Liley Hall
Liley Lane
Mirfield
WF14 8EG

We would like to register our strong objection to Planning Application 2026/62/90880/E for the proposed redevelopment of the agricultural sheds at Liley Hall Farm into residential units.

BUILDING ONE
 PROPOSED GROUND FLOOR
 UNIT 1

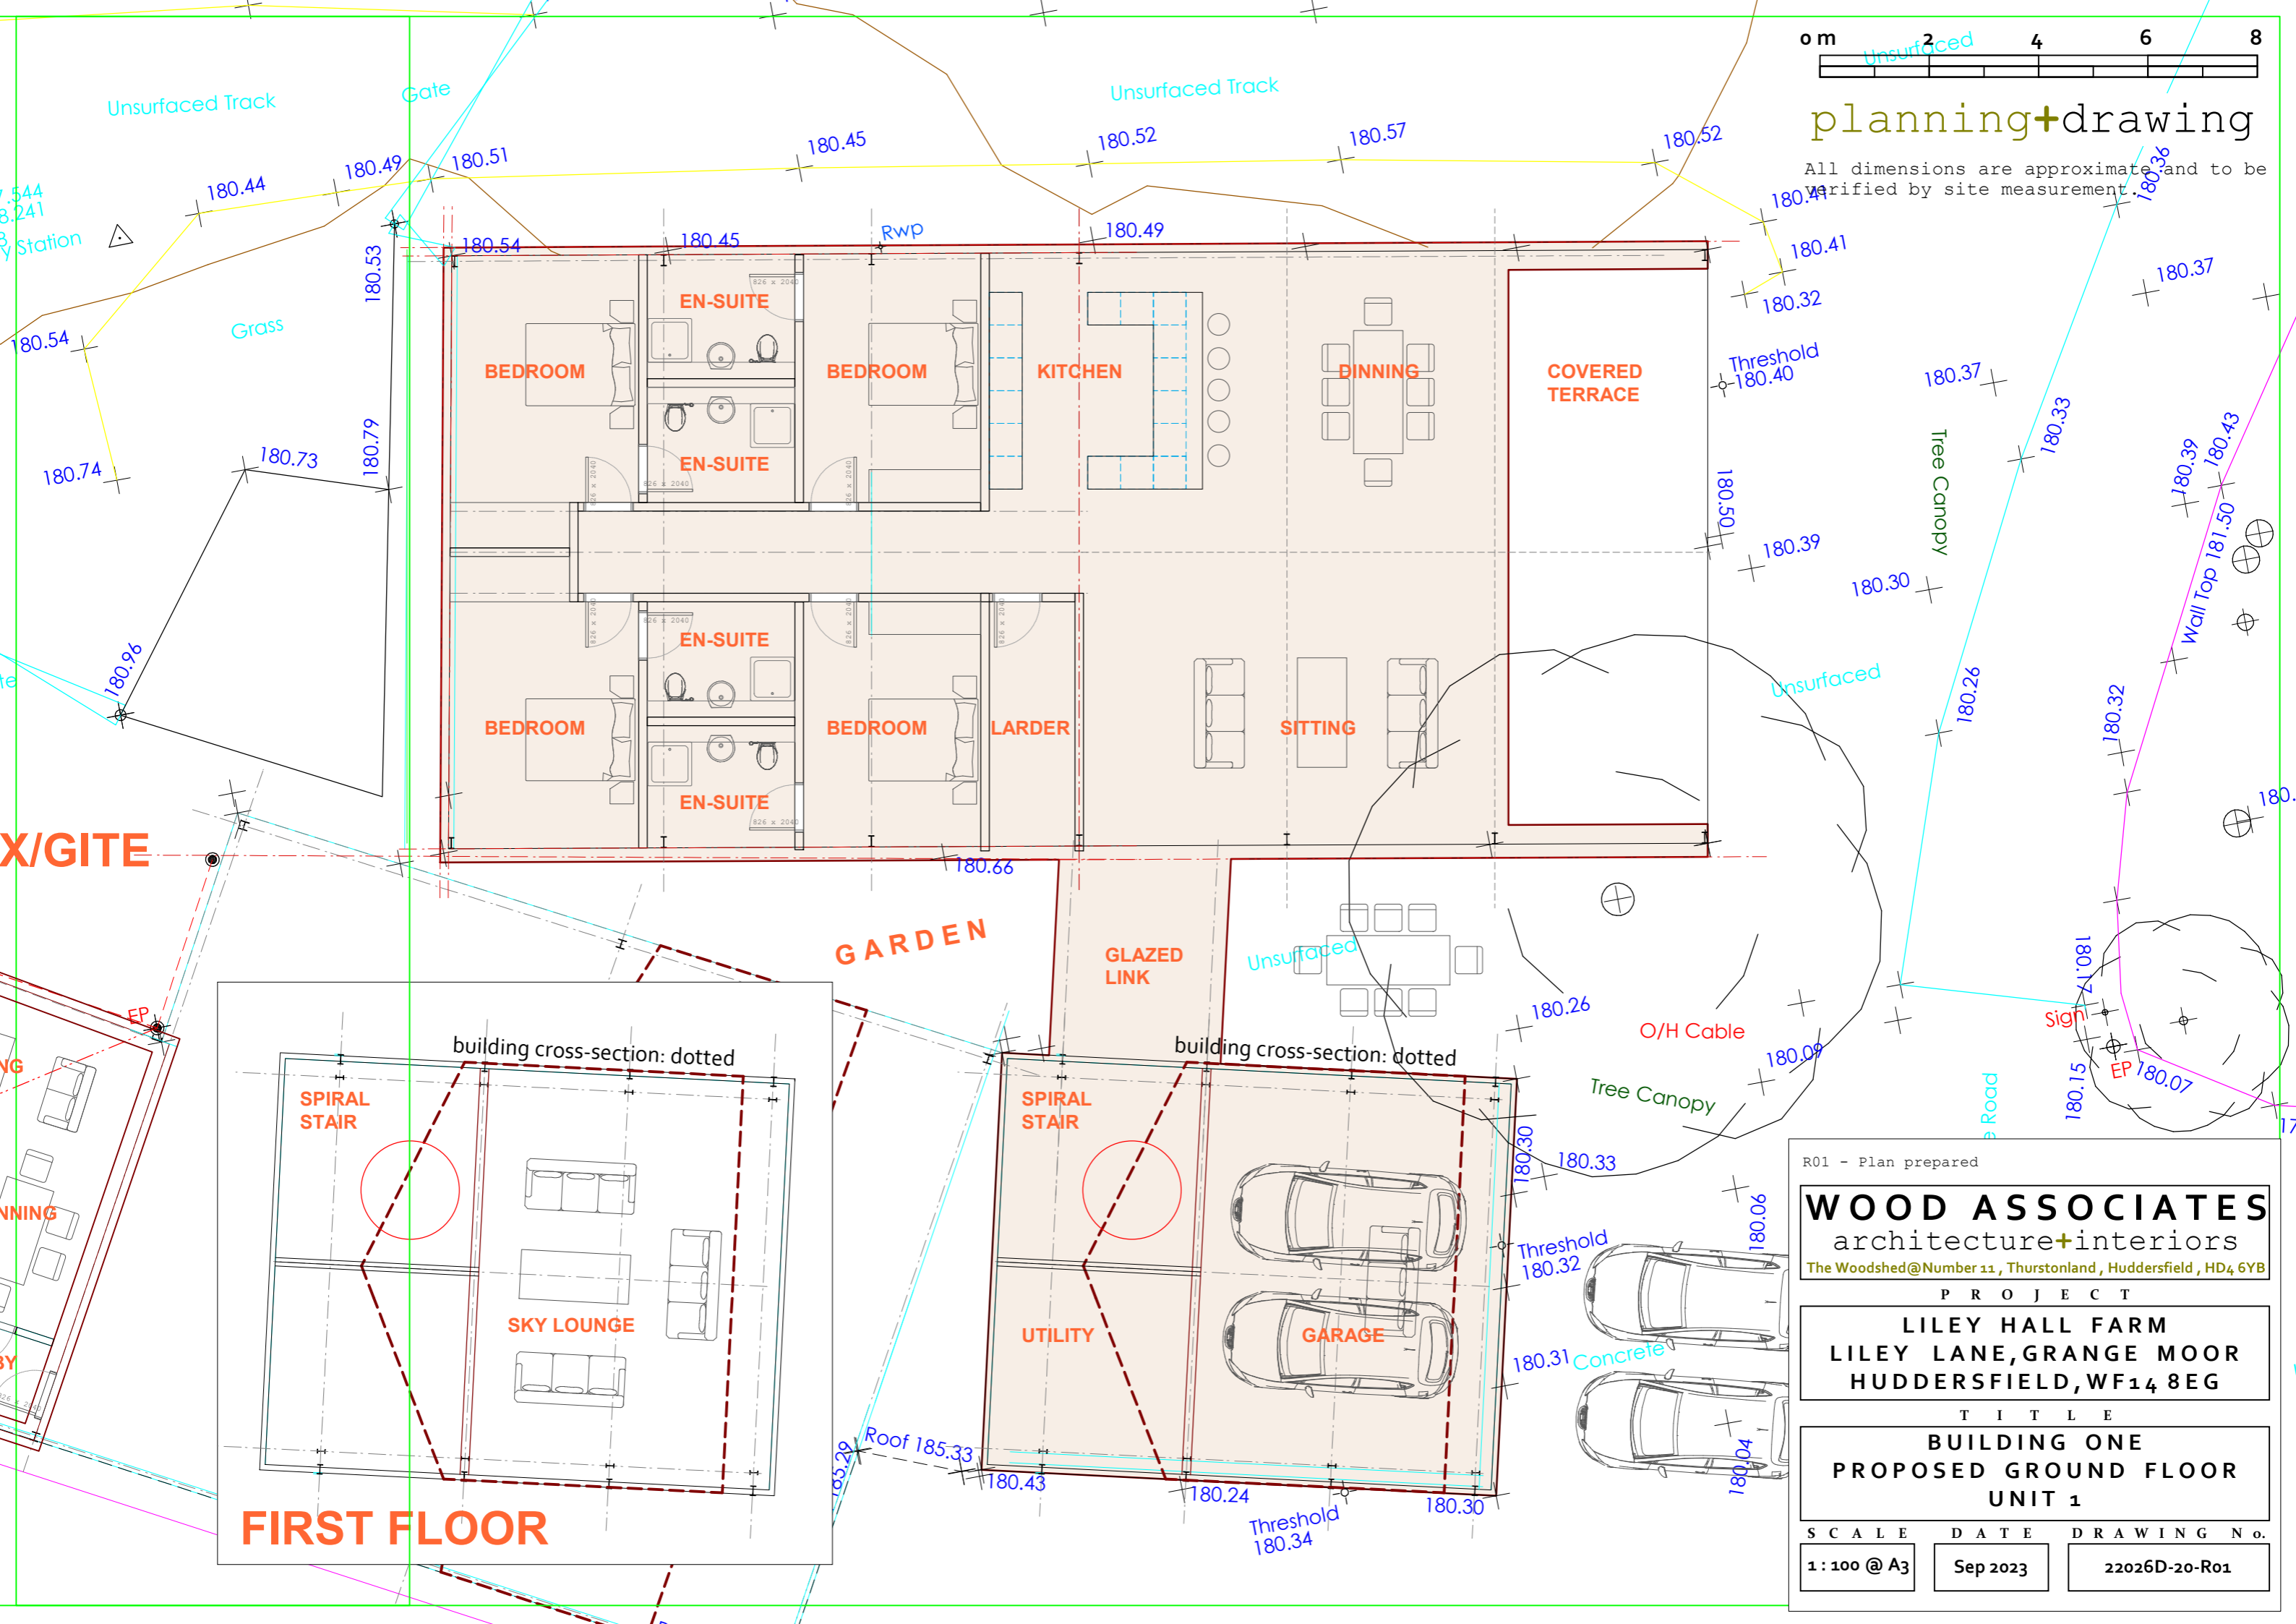
- **Existing Buildings 1-4 (Proposed Unit 1 + Annexe)**
 - Approximately 330sqm for the 5-bed house and 115sqm for the 2-bed annexe
 - Totalling approximately 445sqm (substantially greater than the 150sqm allowed)
- **Existing Building 5 (proposed units 2-4)**
 - Approximately 640sqm for the 3 new dwellings proposed (substantially greater than the 150sqm allowed)
- **Existing Building 6 & 7 (proposed units 5-9)**
 - Approximately 716sqm for the 5 new dwellings proposed (which, when taking into account first floor accommodation, would be *substantially* greater than the 150sqm allowance per unit)
- **Total Built Development Area approximately 1800 sqm**
 - Significantly exceeding the 1000sqm maximum that Class Q stipulates

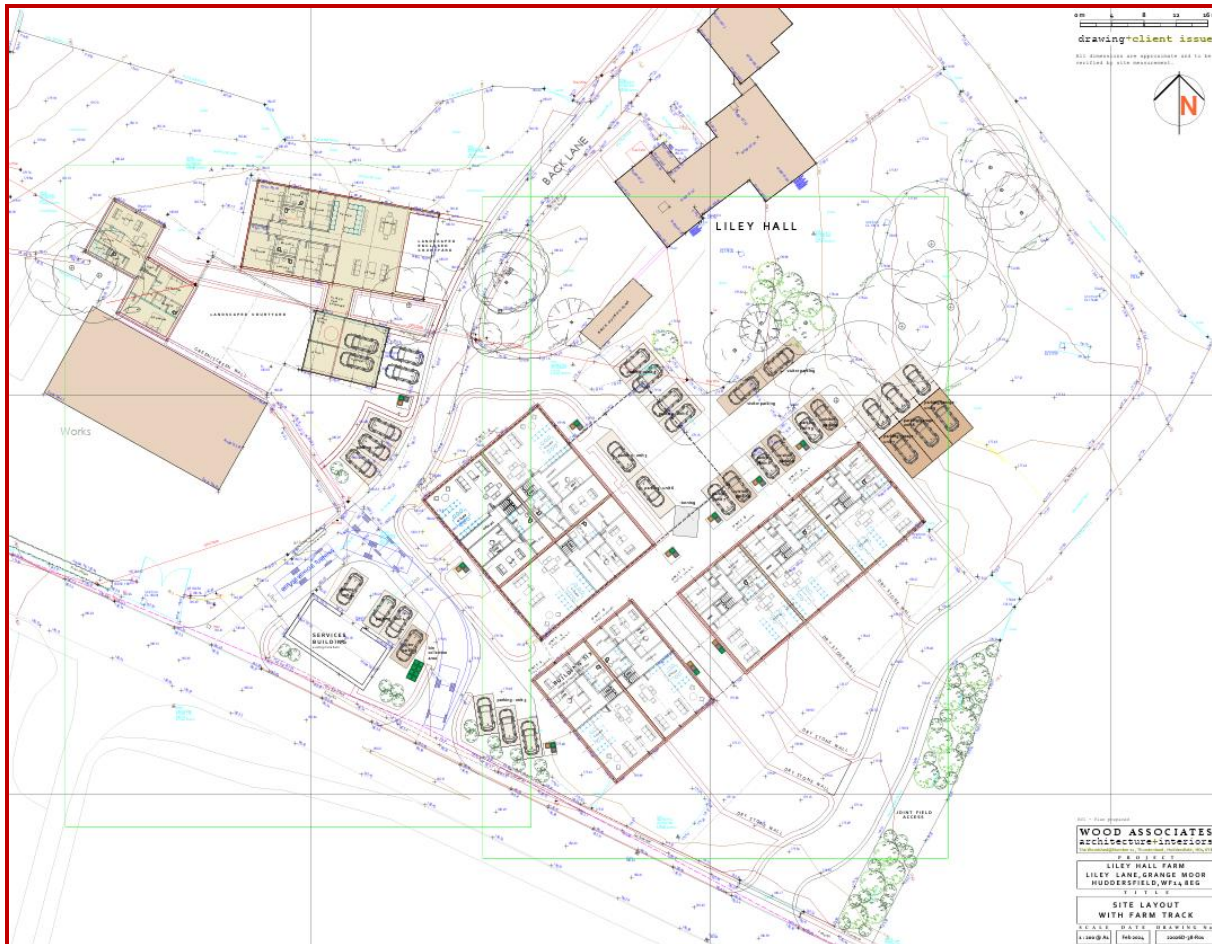
- We have concerns about how vehicular access is to be achieved to units 6-9 on the far side of the site. It appears that a ring road is proposed around the site, bringing increased traffic directly past the Grade II listed Farmhouse and Hall.

- It is also unclear from the information provided whether access is to be focused on the proposed new entranceway, which is less visible from the brow of the hill when approaching from the Mirfield end; or whether access is also to be made available through the existing gate marked 'existing field access' on the site plan.
